Application no: 22/00967/DISC

Location: Land Approx 1 Mile From J9 East Of M40, Part Of M40 Through Chesterton Parish, Chesterton

Transport Development Control

Condition 30

Proposed Ground Floor Plan

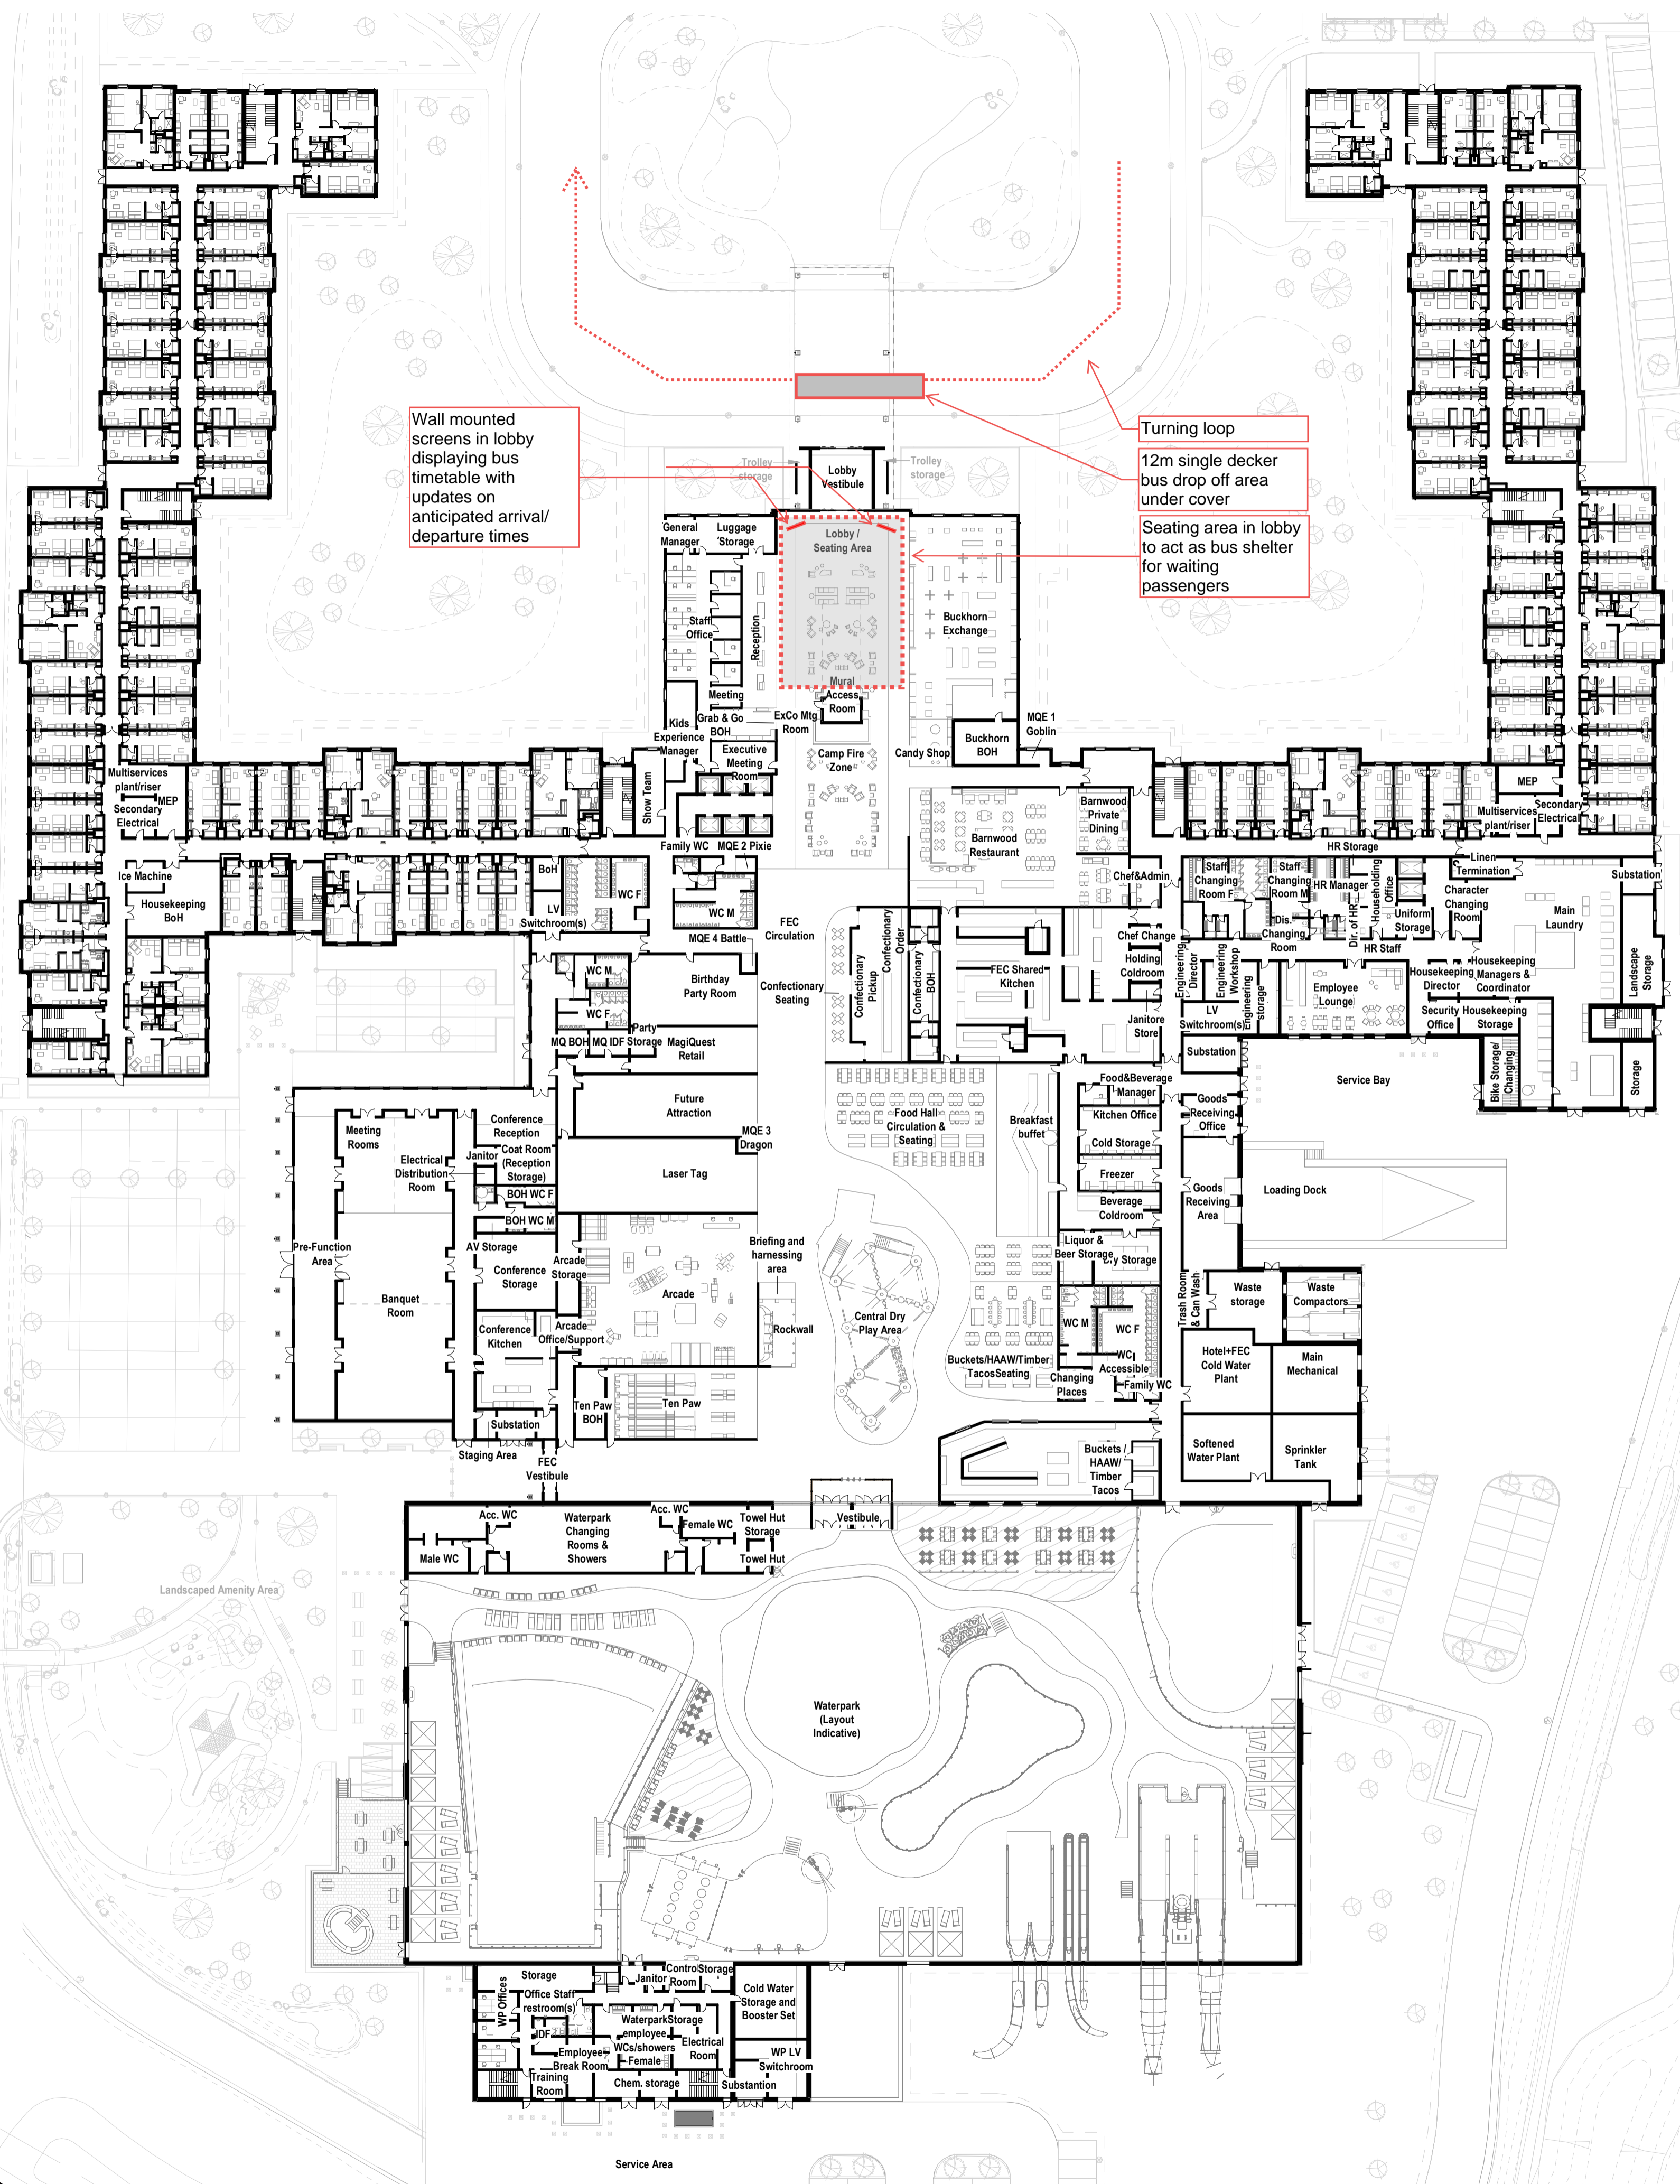
The type of bus used will be limited to a single decker due to the limited headroom under the canopy. This is acceptable as the use of single decker vehicles will be specified in the contract.

Wall mounted screens and a passenger waiting area in the lobby are welcomed as this will help to encourage bus use. There should also be a flagpole outside to formally identify the bus stop. The specification for such a flagpole is as follows:
